**Comments on the additional submission for Planning Application No 6/2018/2768/OUTLINE to build 1100 homes in Ellenbrook Fields, by Hatfield Town Council**

**Strong Objection**

Fig 2

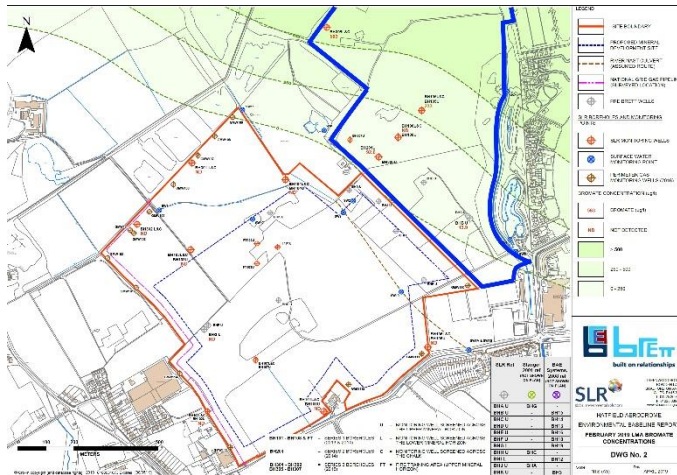
The map below shows the known contamination on Ellenbrook Fields and on this site, with contamination in excess of 1000µg/l. **One hundred times the World Health Organisation limit.**

The latest plume drawing from Hatfield Quarry Application. Over 500µg/l (green) in the North where the planned housing would be:

This map was produced for the quarry application and shows the bromate contours under the housing site (dark green). The blue shows the southern part of the housing application.

Fig 3

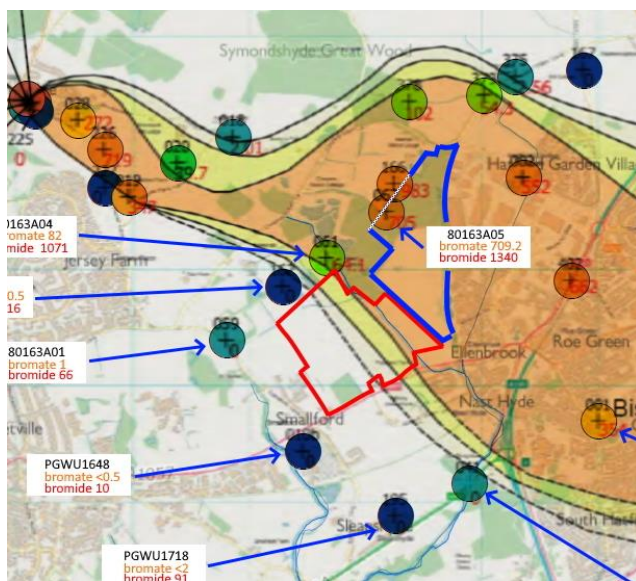
EA plume drawing showing boreholes and housing applicant site. Borehole 80163A05 @ 709.2µg/l bromate is to the West of the housing site.

The EA map is expanded from Part 2A of Environmental Protection Act 1990 St Leonards Court document showing greater than 50µg/l bromate in light red. The site is in the middle of the plume. To the South is the Brett quarry application in red outline.

Fig 4

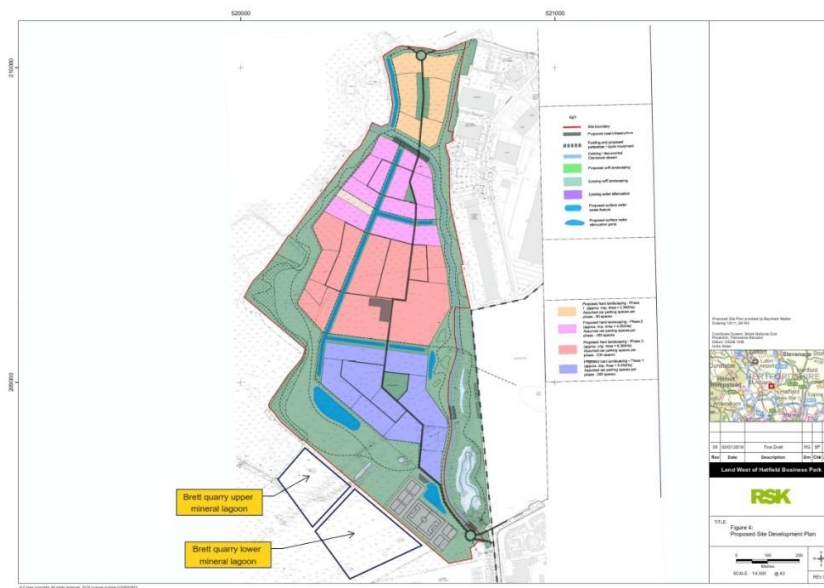
- that there is no mention of “adjacent/overlapping sites” such as the proposed Brett quarry to the East. Attenuation lakes practically touch Infiltration lagoons in a specific area - a catalyst for cross-contamination ...see fig 3.

- The cumulative effect of attenuation lakes in the South and Brett quarry infiltration lagoons in the same area was not taken into consideration Fig 3.

Fig 3 shows proposed Brett quarry lagoons in the South. The expected infiltration rate of the Upper Mineral Horizon is estimated at 1,100 to 2,300 cubic metres/day directly into the same ground that the attenuations ponds (blue) would add another 1000 to 2500 cubic metres/day, from the run off from the new development.

These totals double the groundwater amount, which is now focused on a specific area potentially leading to flooding downstream of the combined sites.

Fig 5

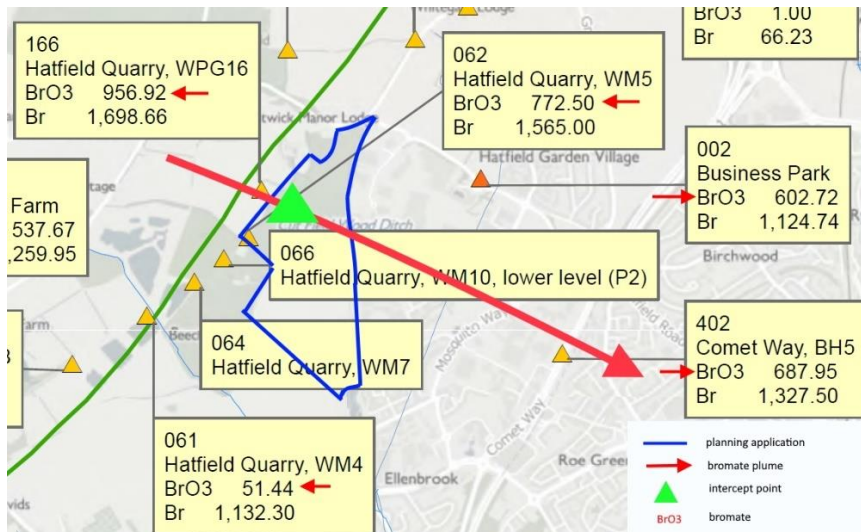
- The objection is that the EA remedial plan using an array of boreholes, perpendicular to the plume and at its highest bromate levels, would require an area to operate that is clear of obstacles and housing.

The intercept point is shown in green. The plume has a S.E direction.
